**KIRKLEES METROPOLITAN COUNCIL
INVESTMENT & REGENERATION SERVICE**

Reference No:	2023/62/93786/W
Site Address:	Sunnyside, 56, Heaton Road, Paddock, Huddersfield, HD1 4HZ
Description:	Erection of rear conservatory
Recommending Officer:	Molly Storer

HOUSEHOLDER DELEGATED REPORT

DRAWING NUMBER: 23/3040/A1

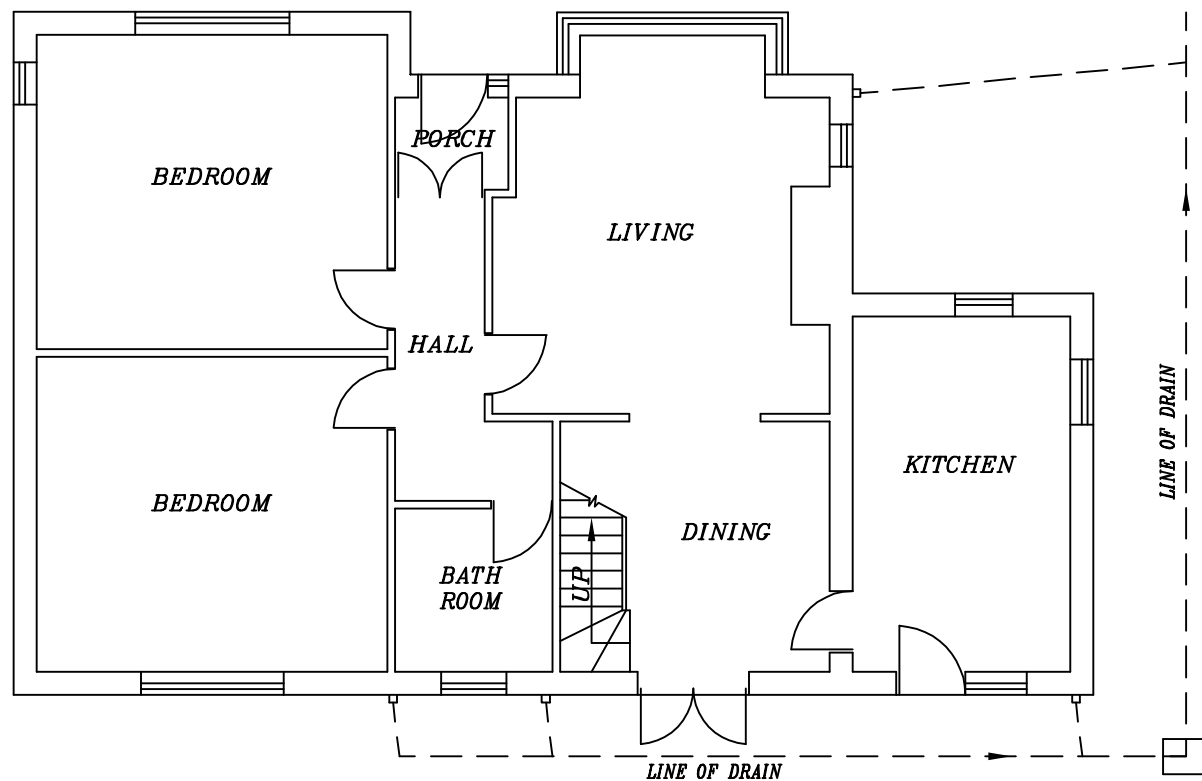
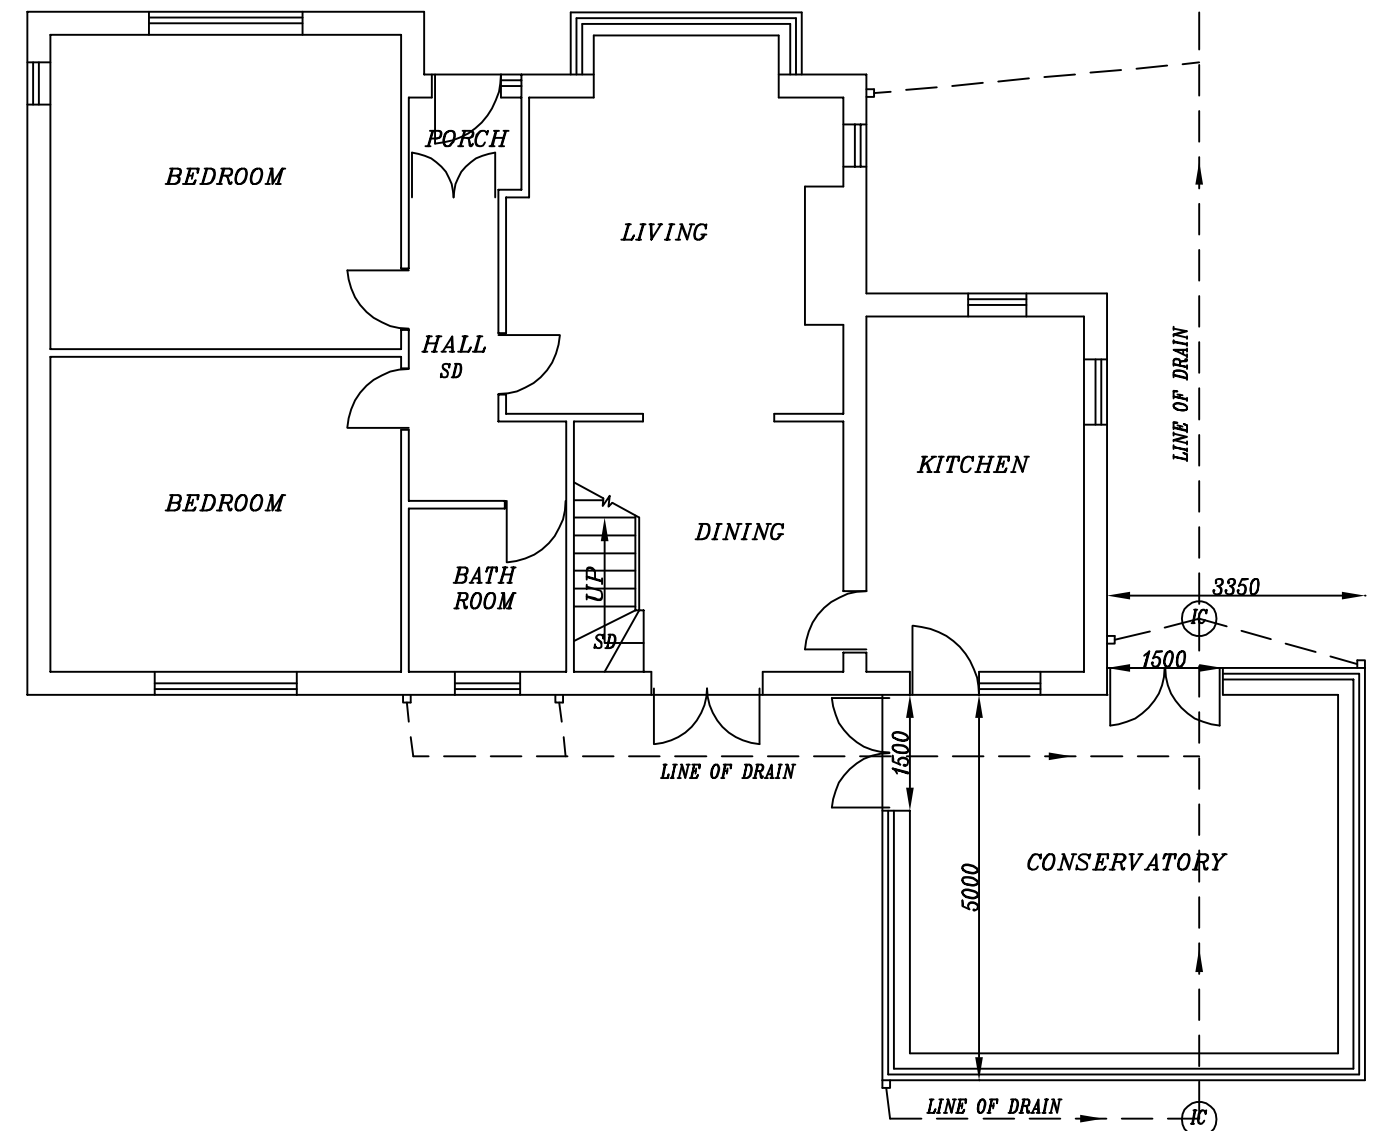
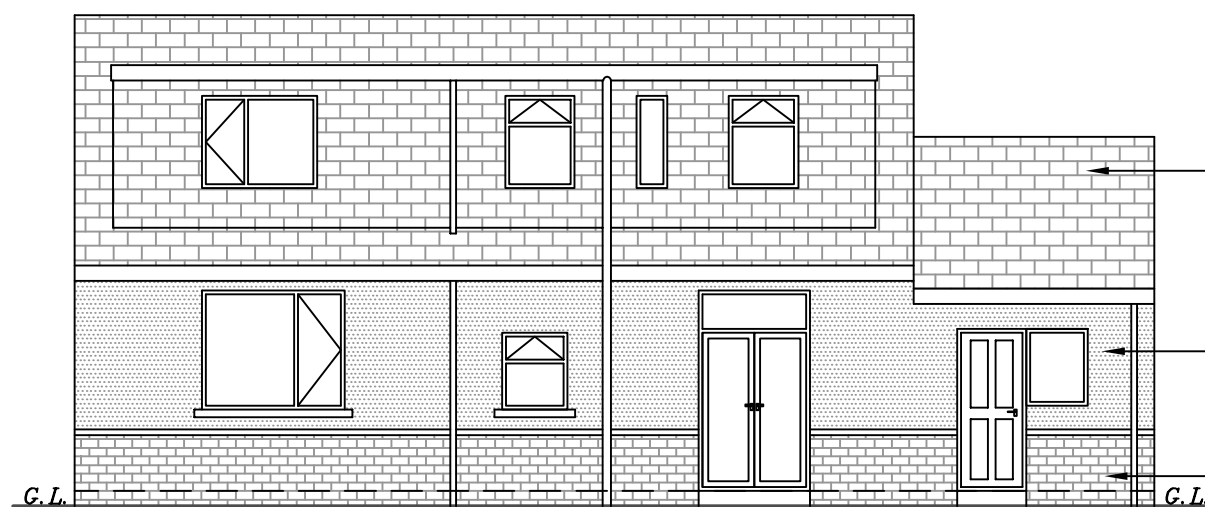
The extension will project 5m from the rear elevation. It is proposed to extend beyond the original side wall by 3.35m therefore will also be classed as a side extension, it will have a full width of 6.3m. The roof would be a hipped roof constructed from glass panels.

The bottom part of the conservatory walls will be constructed from blocks painted white to match the original dwelling, the higher section will be constructed from white uPVC window panels and the roof from white uPVC roof panels.

Roof style	<ul style="list-style-type: none"> • KDP 1 and 2 of the SPD • Policy LP24 Design (a), (c) and (d) of the KLP • Chapter 12 of the NPPF 	Partial lean-to roof design to match that of the adjoining neighbours extension and partial gable roof design to match that of the original house.	✓
Window proportions	<ul style="list-style-type: none"> • KDP 1 and 2 of the SPD • Policy LP24 Design (a), (c) and (d) of the KLP • Chapter 12 of the NPPF 	All elevations will include glazed panels however due to the enclosed nature of the property's rear and due to the extension being built on a lower ground level the glazing is not considered to cause significant harm.	✓

3. Notwithstanding the plans submitted the external dwarf walls of the development hereby approved shall in all respects match those used in the construction of the existing building and be retained thereafter.

DRAWING NUMBER: 23/3040/A2

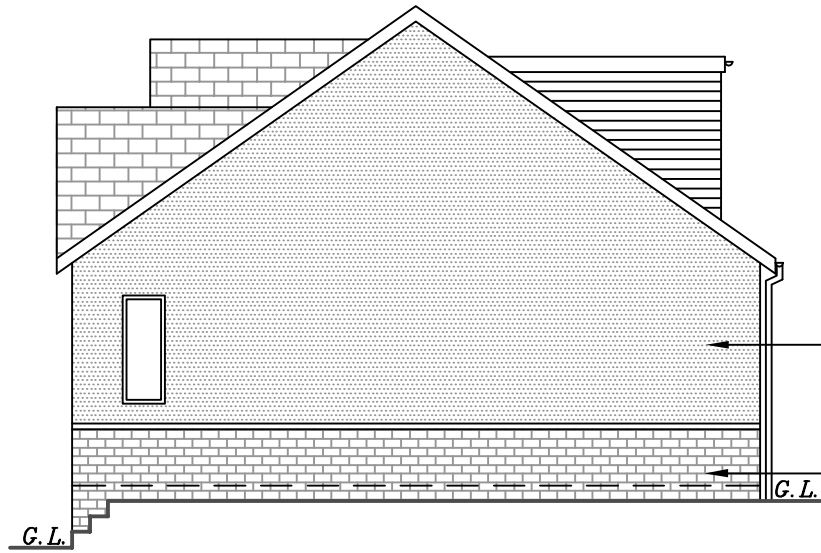
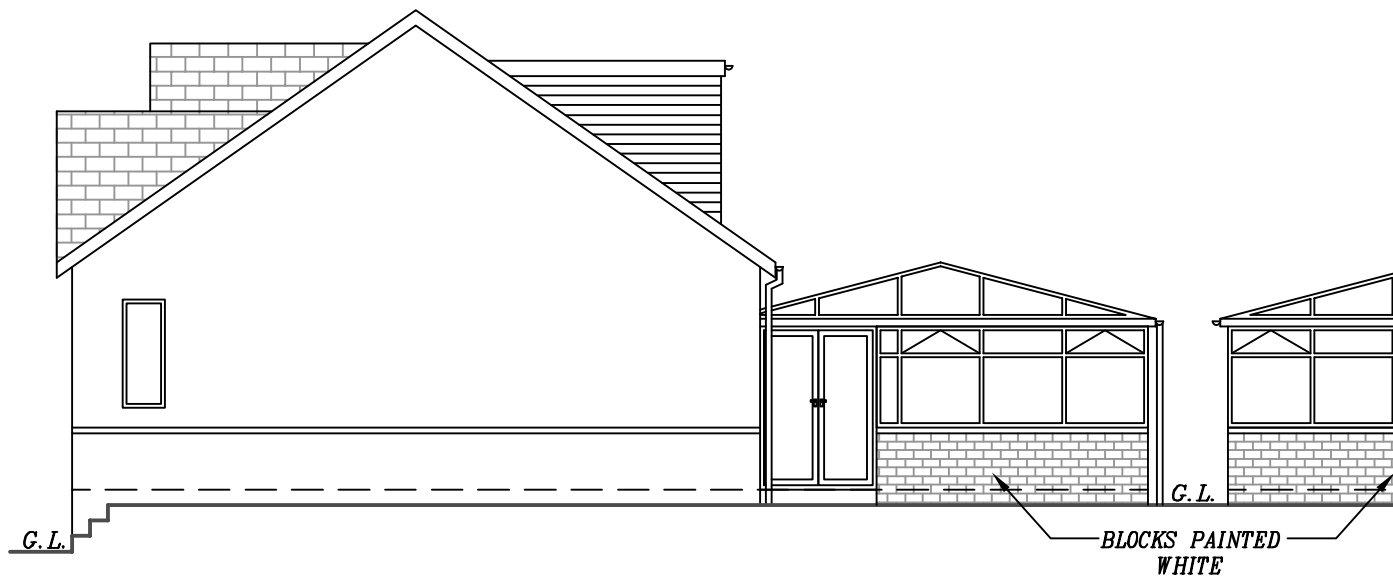
Side extensions	<u>Yes - COMPLY</u>	<u>No - JUSTIFY</u>
Ensure reasonable levels of natural light to the habitable rooms in neighbouring properties	Yes – The extension would not be built up to the boundary of No.58 limiting the impacts. The 1.1m gap will allow for reasonable levels of natural light into the side elevation of No.58.	
Positioning windows to minimise or avoid any potential overlook into neighbouring gardens	Yes- the side elevations will be fully glazed however the extension will be constructed at a lower ground level and will face onto a side elevation at No.58

which hosts no openings.	
Single storey side extensions should:		
not extend more than two thirds of the width of the original house	Yes – the extension will have a limited projection of 3.35m beyond the side elevation.	
not exceed a height of 4 metres	Yes – height of 3.2 meters.	
be set back at least 500mm from the original building line to allow for a visual break	Yes – set a significant distance behind the original building line.

Impact on light and outlook of neighbours (to sides, rear and front)	<ul style="list-style-type: none"> • KDP 4, 5, 6 of the SPD • Policy LP24 Design (b) • Chapter 12 of the NPPF 	Once part of the rear garden is levelled out to make way for the extension this will be at a slightly lower ground level to No.58. Due to this and the 1.1m gap to the boundary it is not considered to cause significant overbearing or overshadowing.	✓
Remaining garden space of application property	<ul style="list-style-type: none"> • KDP 7 of the SPD • Policy LP24 Design (b) and (c) • Chapter 12 of the NPPF 	Acceptable level of remaining garden space.	✓
